PLANNING CONSULTATION RESPONSE

Application No	2026/0406
Proposal	Formation of new detached residential property, including forming driveway and garden area
Address	1 Kensington Avenue, Thurlstone, Sheffield, S36 9RU
Date of Consultation Reply	17 th June 2026
Consultee	Highways DC

Site Plan (Scale 1:200)

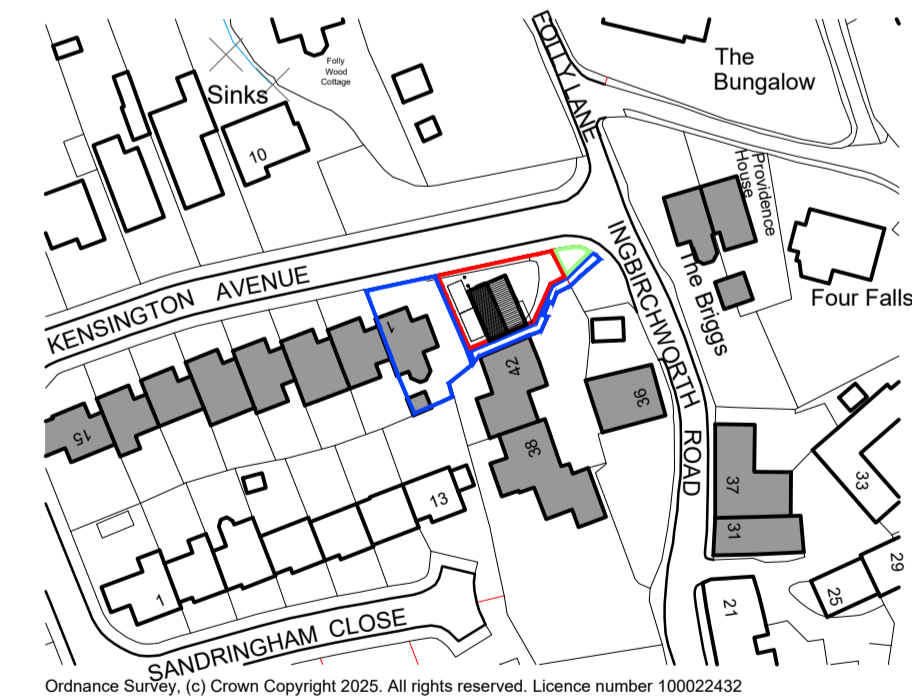
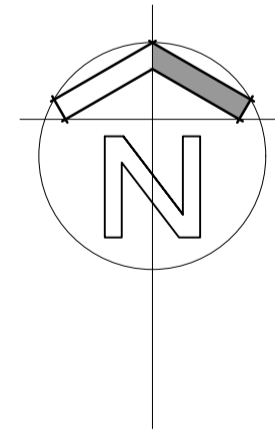
It is proposed to erect a single detached dwelling on a plot of land which currently forms part of the side garden area of no.1 Kensington Avenue. The proposed site layout plan shows that two off-street parking spaces of sufficient dimensions are to be provided for the new dwelling which is in line with the Councils' Supplementary Planning Document (SPD) Parking (2019).

The proposed new vehicular access has a width of 3.6m which allows the required 2m x 2m pedestrian visibility splays to be achieved; also, the access is positioned in excess of 20m from the Kensington Avenue junction with Ingbirchworth Road which is sufficient to avoid conflict between vehicles entering Kensington Avenue and vehicles manoeuvring into/out of the site access.

The access and parking facilities, indicated on the submitted plan, shall be surfaced in a solid bound material (i.e. not loose chippings) and made available for the access and parking of motor vehicles prior to the development being brought into use, and shall be retained for said purposes at all times. Adequate measures shall be so designed into the proposed vehicular areas to avoid the discharge of surface water from the site on to the highway.

The gradient of the vehicular access/driveway shall not exceed 1 in 12 as measured from the edge of the adjacent carriageway.

Prior to the development being brought into use, the vehicular access shall provide pedestrian visibility splays of 2m x 2m to the back edge of the footway. Nothing shall be erected, retained, planted and/or allowed to grow at or above a height of 0.6m to the rear of the footway which would obstruct the visibility splays. The visibility splays shall be maintained free of obstruction at all times thereafter for the lifetime of the development.
